Response to Submissions

330 Church Street, Parramatta

MP10_0171 MOD 3

26 September 2013

01 ELEVATION - WEST
1.200 @ A1

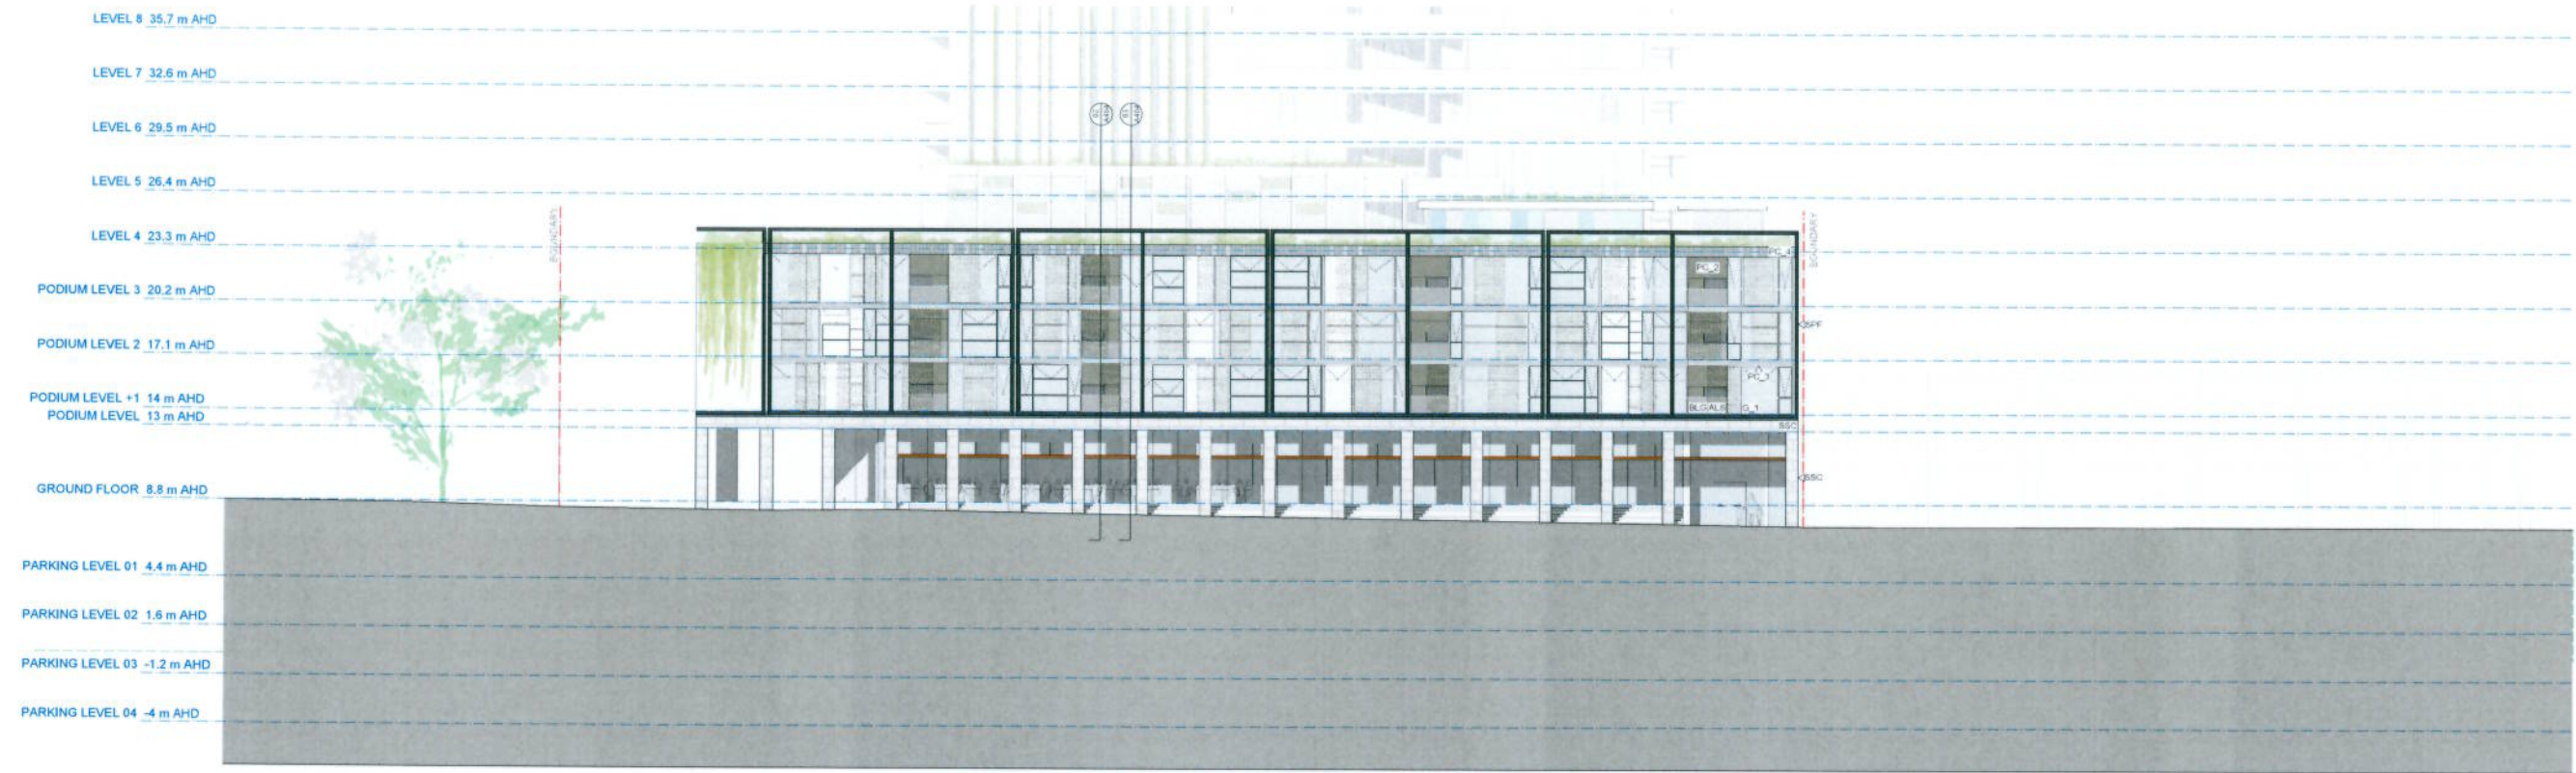
The department supports the proposed increase in podium height; however the department has concerns with the architectural detailing of the podium. In this regard, the department considers that the podium should be redesigned to:

- *Delete the steps adjacent to the western elevation of the building to provide a seamless accessible connection between the street, the colonnade and the internal floor areas of the development;*
- *Provide further modulation of the ground floor retail spaces to ensure the final design of the podium provides an appropriate response to the fine grain character of Church Street; and*
- *Remove the pool shade structure, or set it back from the parapet to achieve a more streamlined podium.*

The amended plans at **Annexure 3** show that the proposed podium has been amended by relocating the swimming pool building. It has been set back from the Church Street elevation, which reduces the apparent height of the podium along Church Street.

Mullions have been added to the ground floor retail spaces to add fine grain detail to the elevations facing the public domain of Church Street and the riverside.

01 PLAN - SITE ANALYSIS

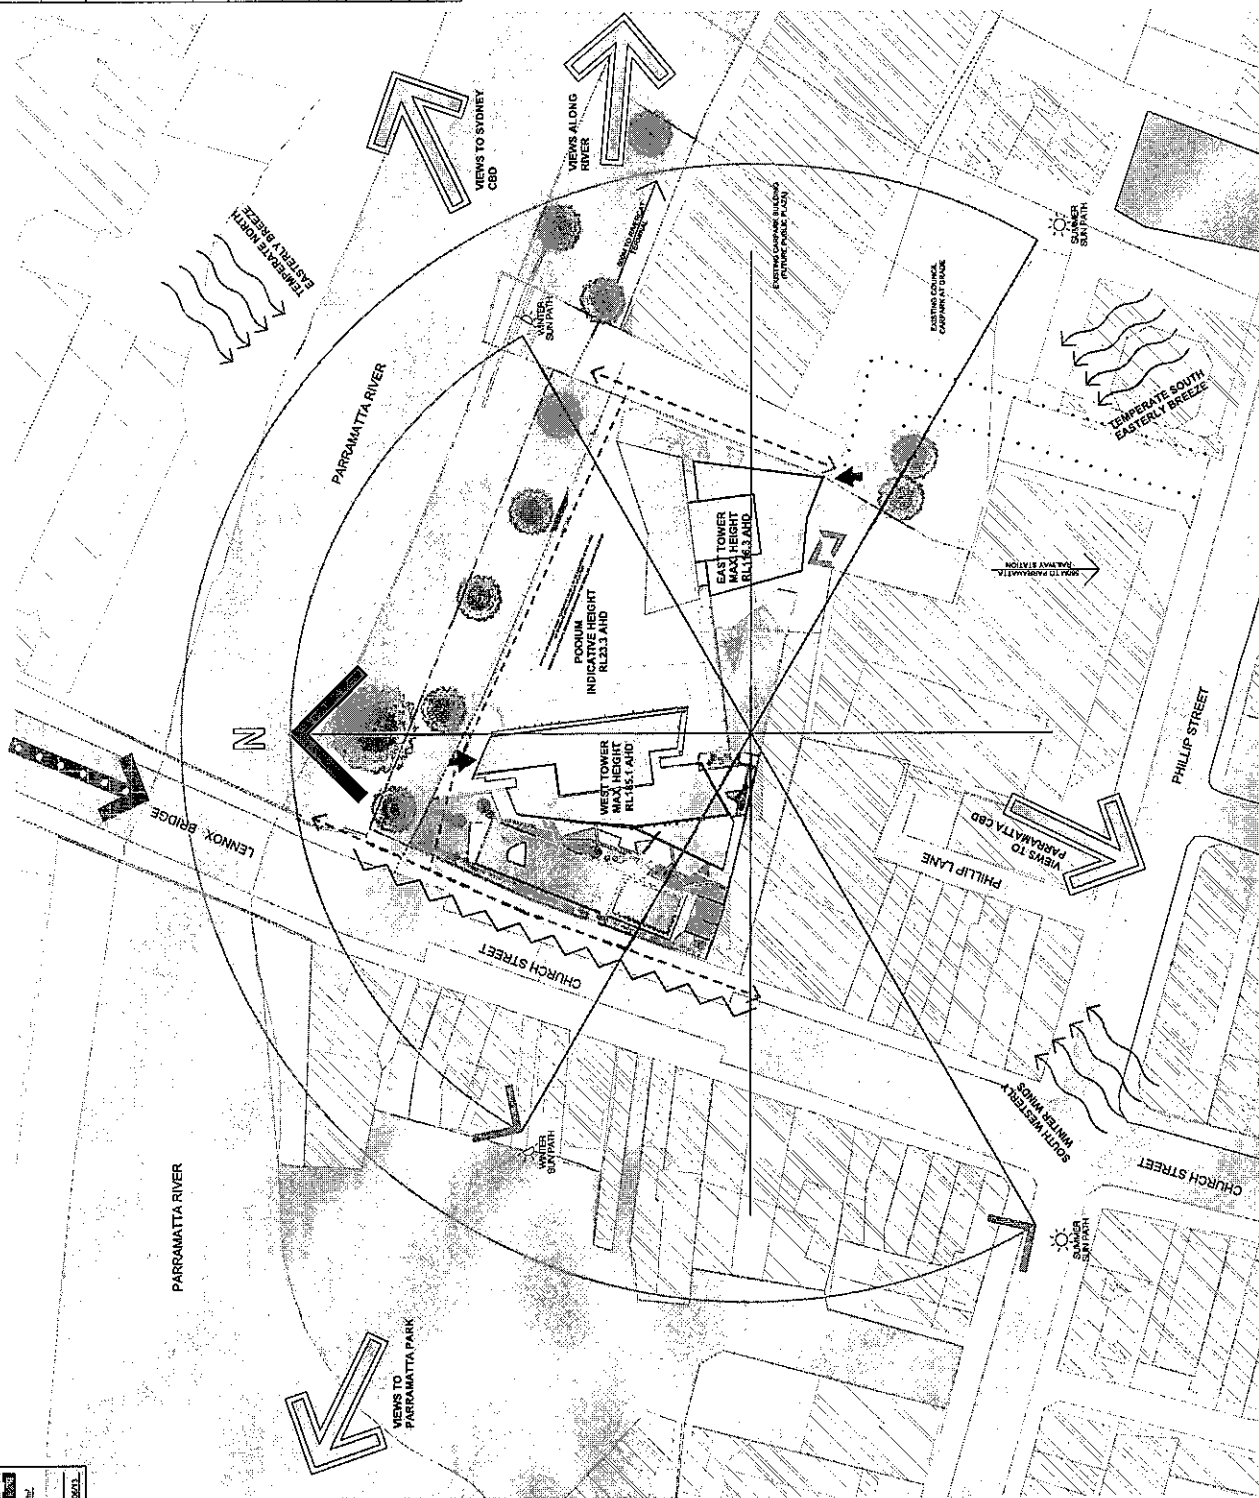
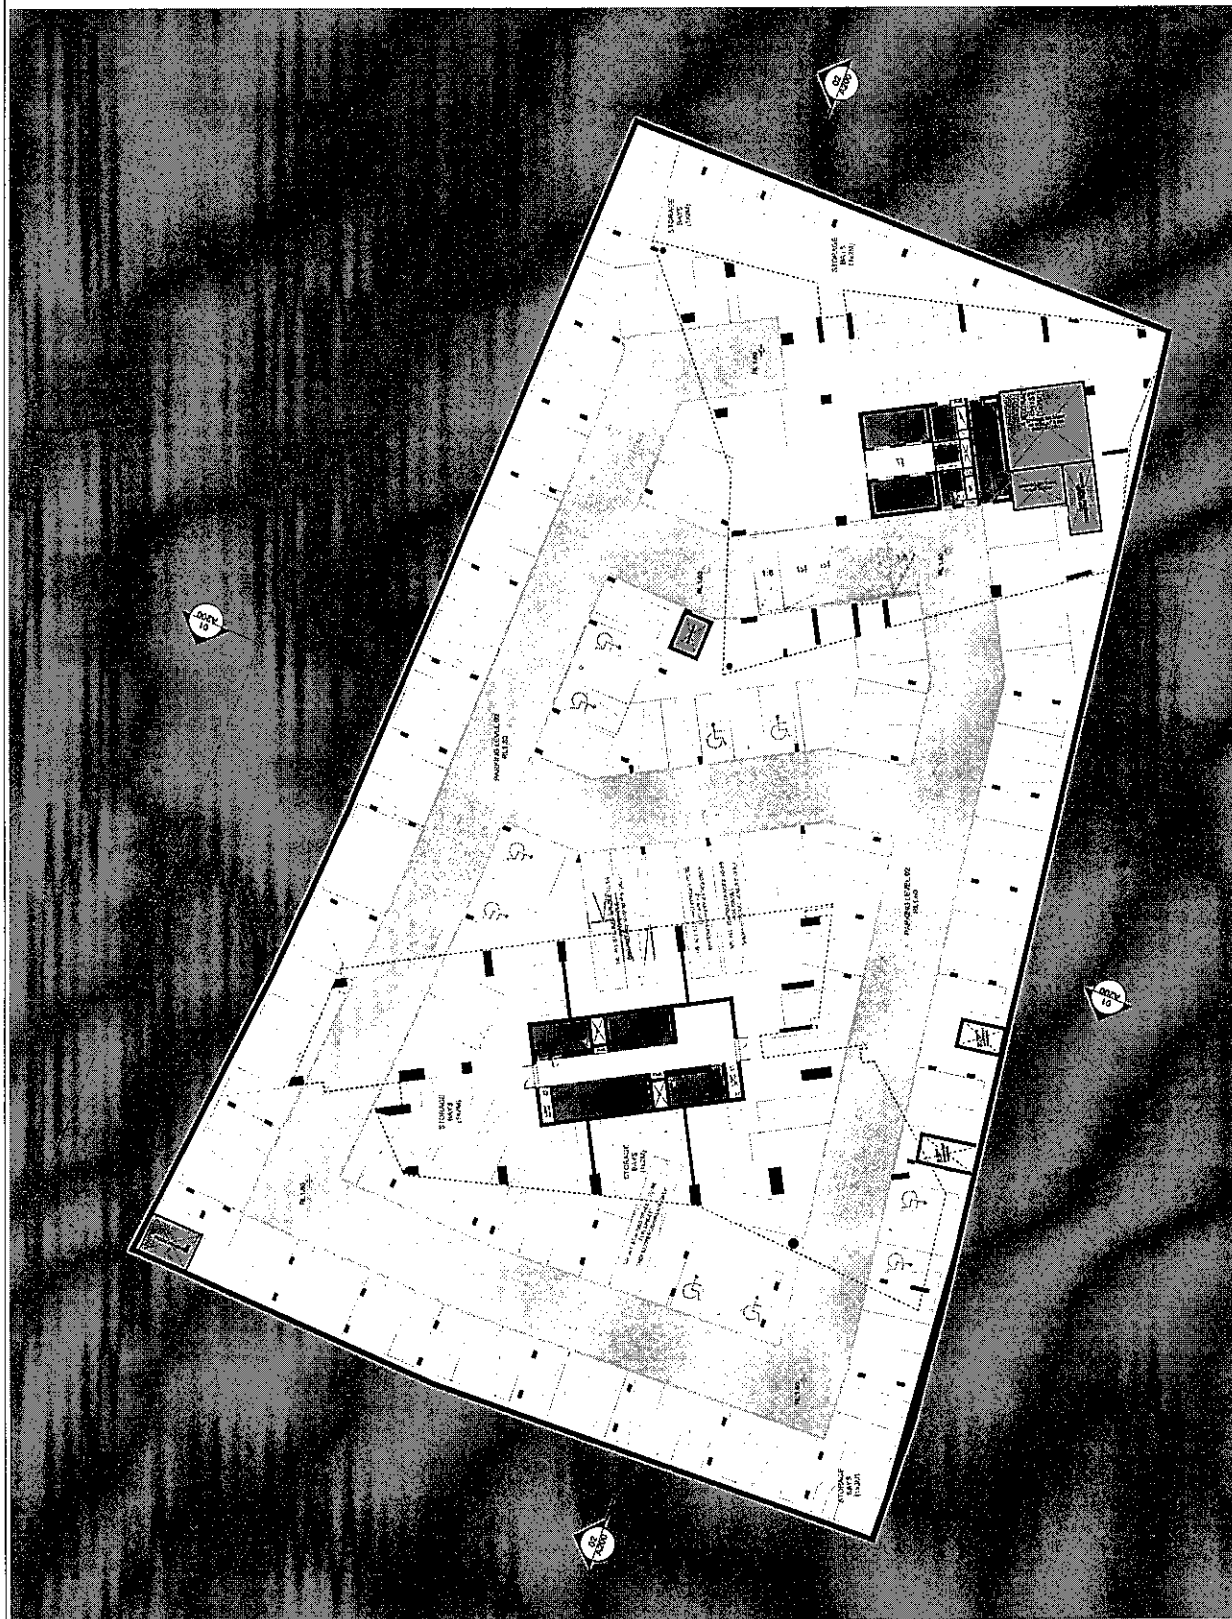
There is insufficient detail to enable an understanding of how the transition in levels adjacent to the eastern boundary of the site and the eastern tower lobby will be resolved. Further details should be provided to identify how an accessible path of travel will be provided from the public domain adjacent to the eastern boundary of the site and the eastern tower lobby.

The department is concerned that the design of the driveway entry to the site will result in vehicular and pedestrian conflicts on land that will be redeveloped by the council as a future public square. Additional details should be provided to identify how the driveway located on the south-east corner of the site will be designed to ensure that these conflicts are minimised. The information submitted to address this issue must include:

- *A site plan which extends to Phillip Street which illustrates how pedestrians will obtain access from the footpath to the lobby entrance; and*
- *Plans depicting the location of all security gates/roller doors and card readers.*

Plan A001 (site analysis) has been updated and is included at **Annexure 3**. The plan now clearly illustrates the path of travel between Phillip Street and the site, for both vehicles and pedestrians.
